Enlargement of garage to north elevation
33 Sea Way Middleton-on-Sea Bognor Regis

Thank you for your internet representation made on 4th December 2013 which has been recorded as '**an objection**' with the comments as follows:

Holm Oak

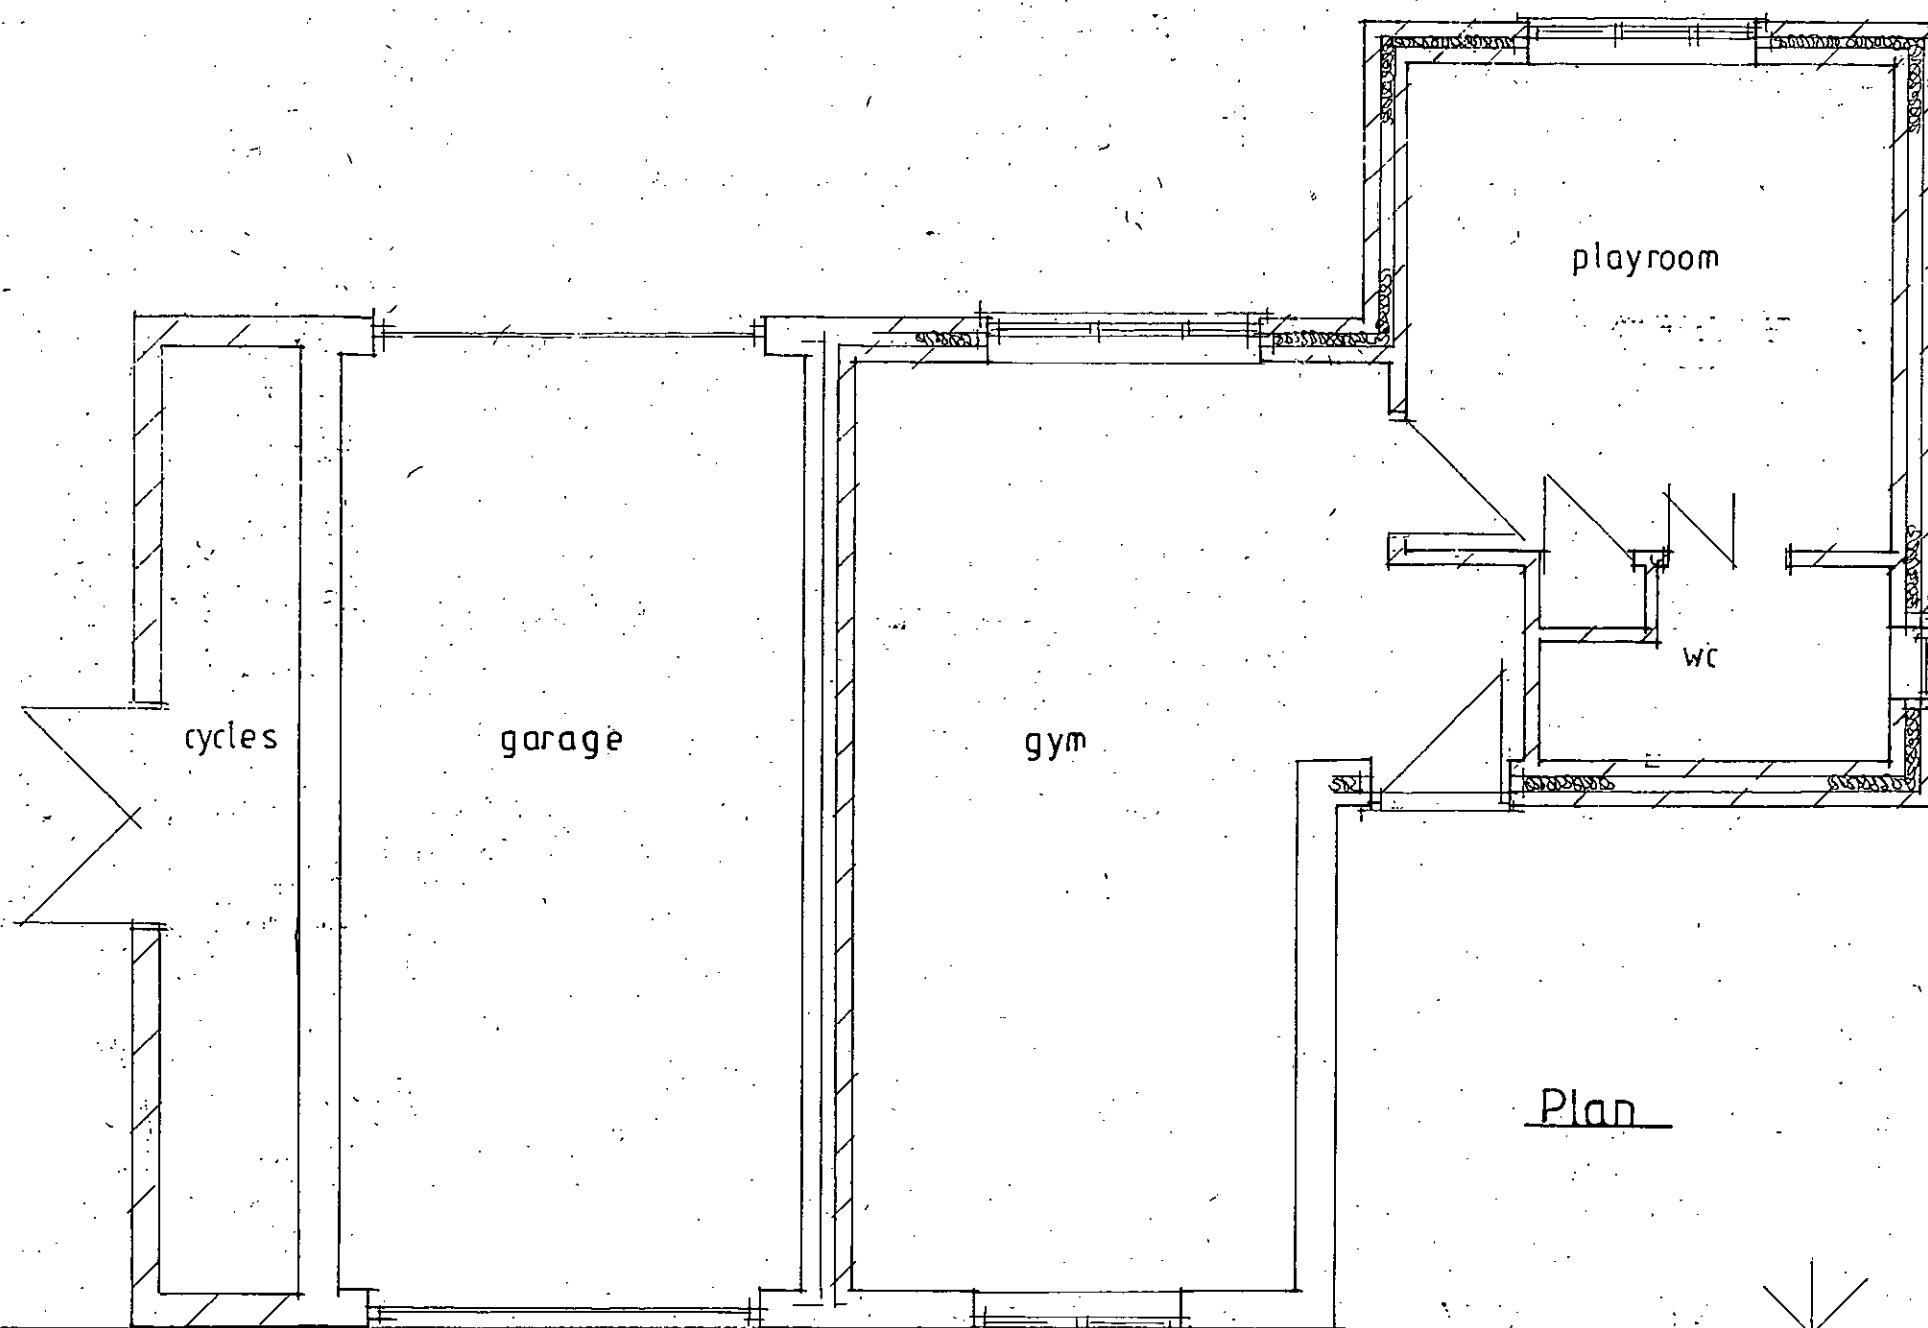
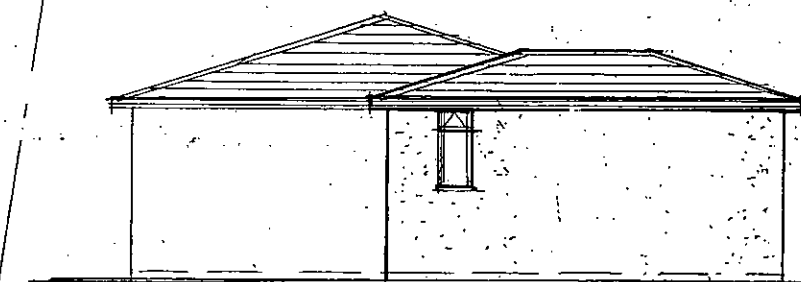
The proposal could mean the loss of a tree on the northern boundary, the tree has not been shown on the submitted plans, the tree adds to the visual character of Sea Way within this area of Special Character,
